LU/124/21/PL

18-22 East Street Littlehampton BN17 6AW

Change of use from C2 Residential Institution to HMO (Sui Generis)

Drawing Title
Existing Floor Plans and Elevations (18-20)

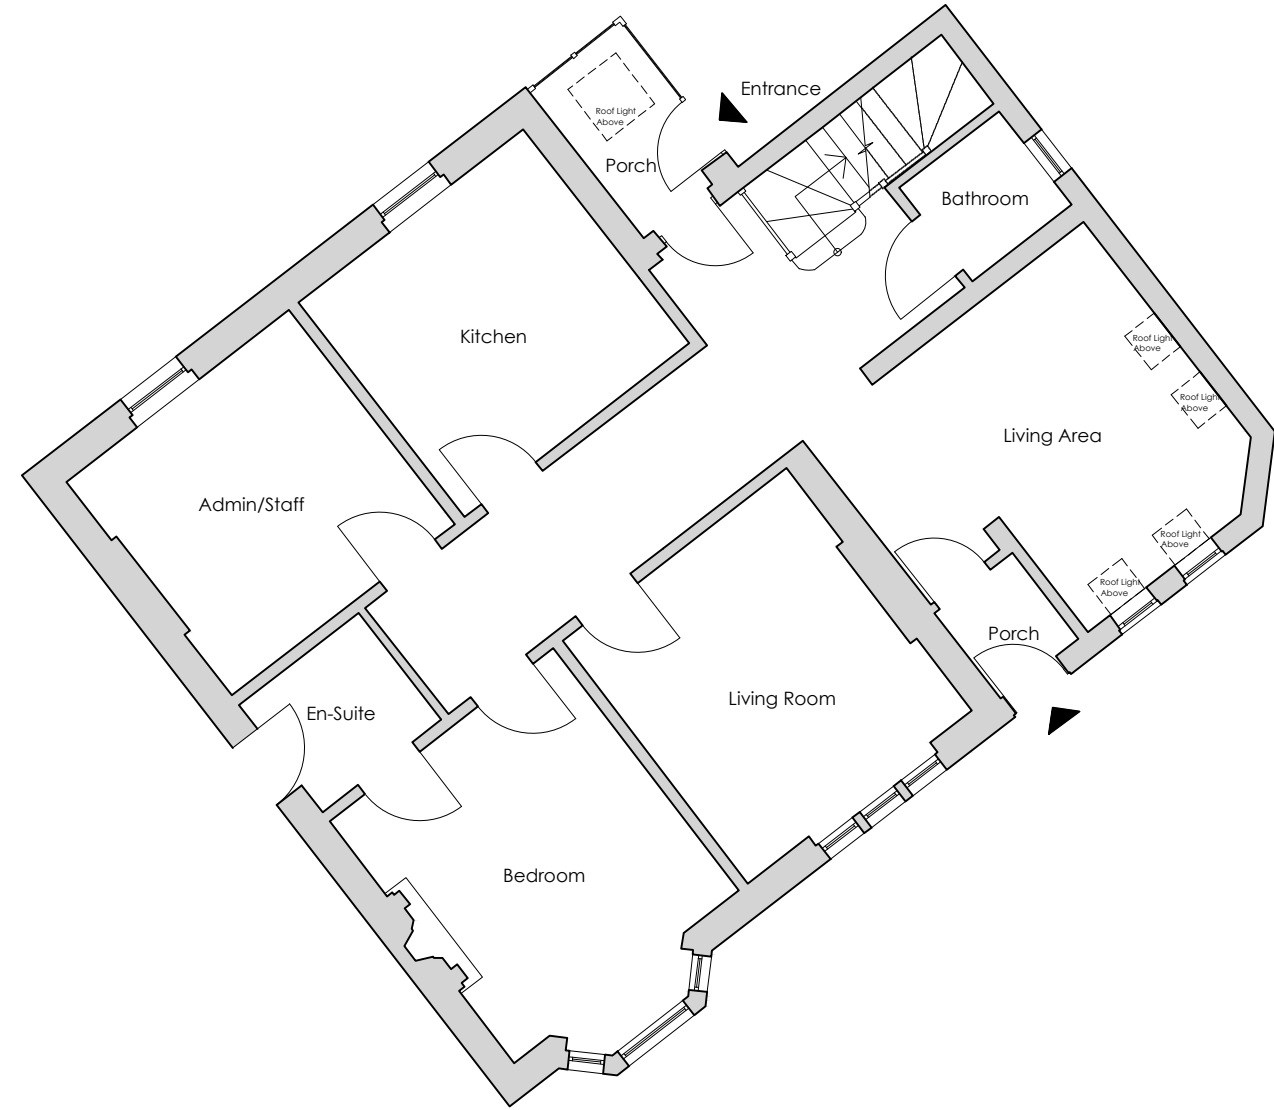
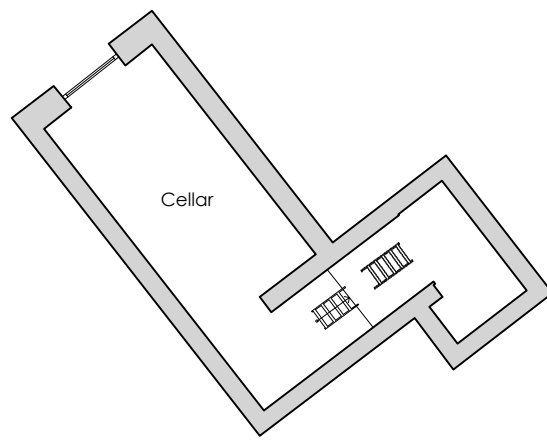
elevations of the buildings. However, it is not clear if the large sign on numbers 18-20 would remain or be removed. Its removal would be supported.
